Boston Alternative Energy Facility

Secretary of State Additional Information Request

**Natural England's updated advice on Ornithology impacts**

8<sup>th</sup> December 2022

Figure 2 Ground view of securable land behind sheet-pile wall in south bank of The Haven (credit: Andrew Chick Ecology)

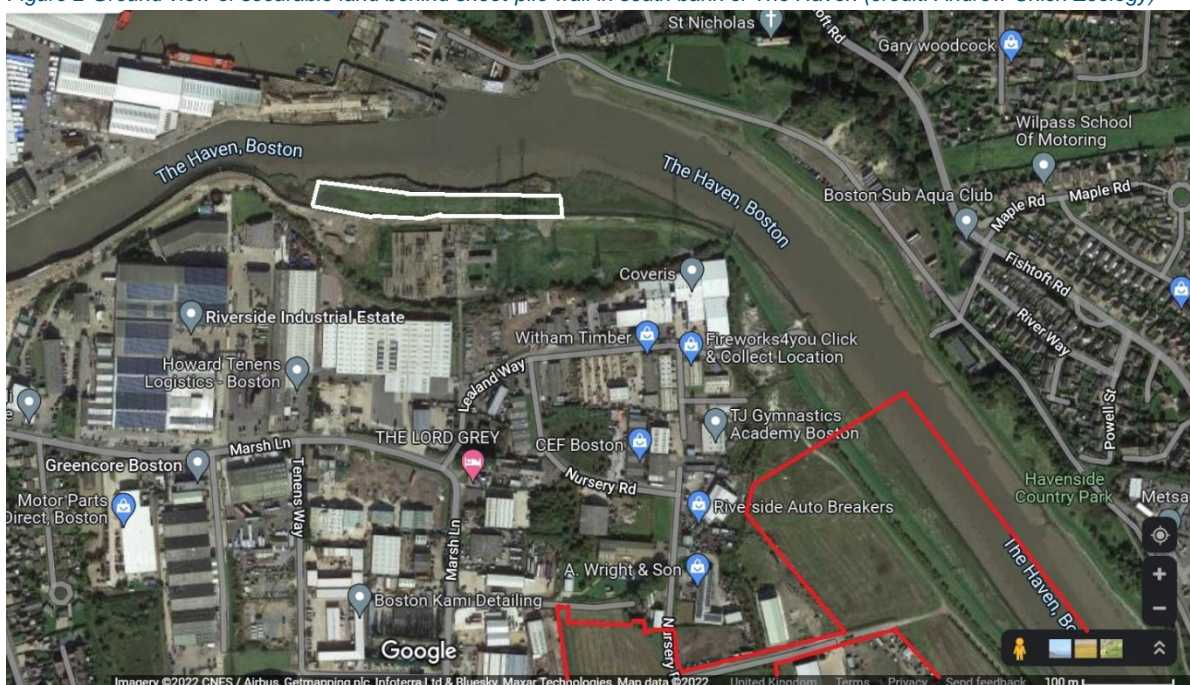
2.8.35	Natural England is supportive of the exploration of the dock level roosting site especially if it will be less disturbed than the mitigation area.	Further detail

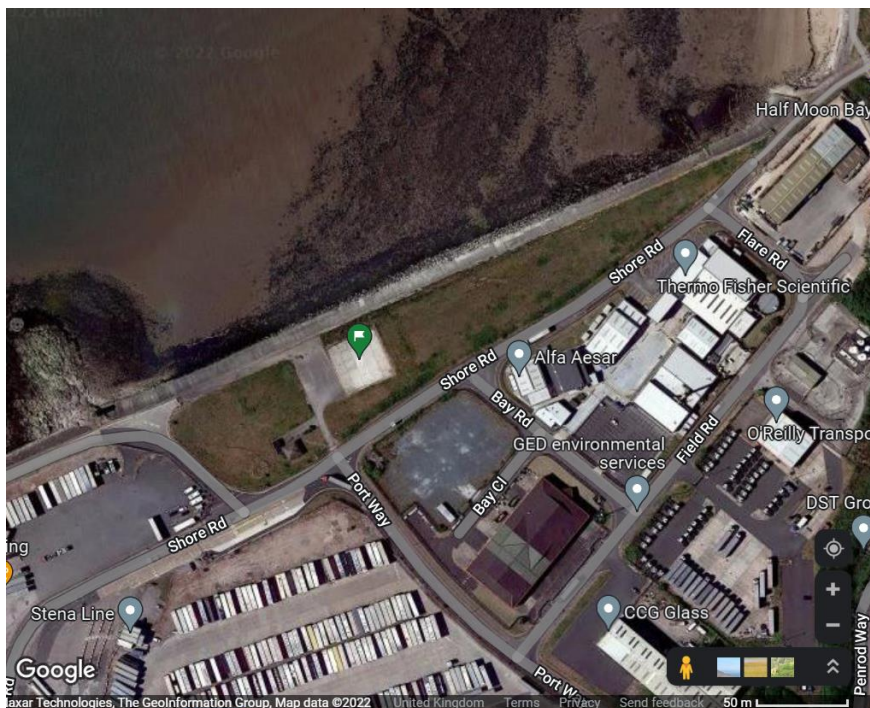
2.8.39	<i>Heysham Heliport wader roost, Lancashire</i> – Natural England's ornithologist is familiar with this site. We agree that when people are kept well back it works for the birds. However, we are not clear how comparable the standoff distance is for the proposed Boston site. We require critical information on the boat/recreational disturbance at the Boston site – the Heysham site is periodically emptied at high tide by windsurfers and kayaks. The Heysham site also has space for the birds to retreat over the wall top on big tides while still being separated from people. How will be this be replicated at BAEP?	Further detail

Figure 6 Elevated view showing roost site (behind gateway) used by redshank and other waders and gulls in the Port of Seaham (copyright: The Lookout/Meta)

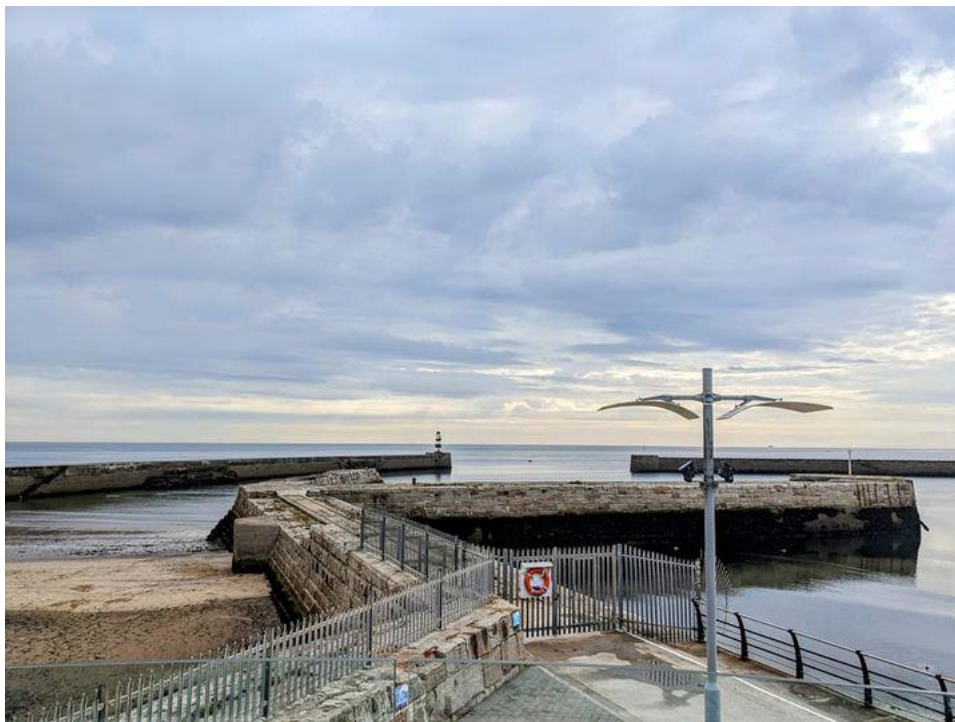
2.8.40	<i>Seaham Harbour and Marina, County Durham</i> – Natural England doesn't know this site, but are aware of comparable ones. Thereby, we can agree the principle presented, but much greater detail is required in relation to BAEP, but we could advise with certainty that the impacts would be offset by the proposals.	Further detail
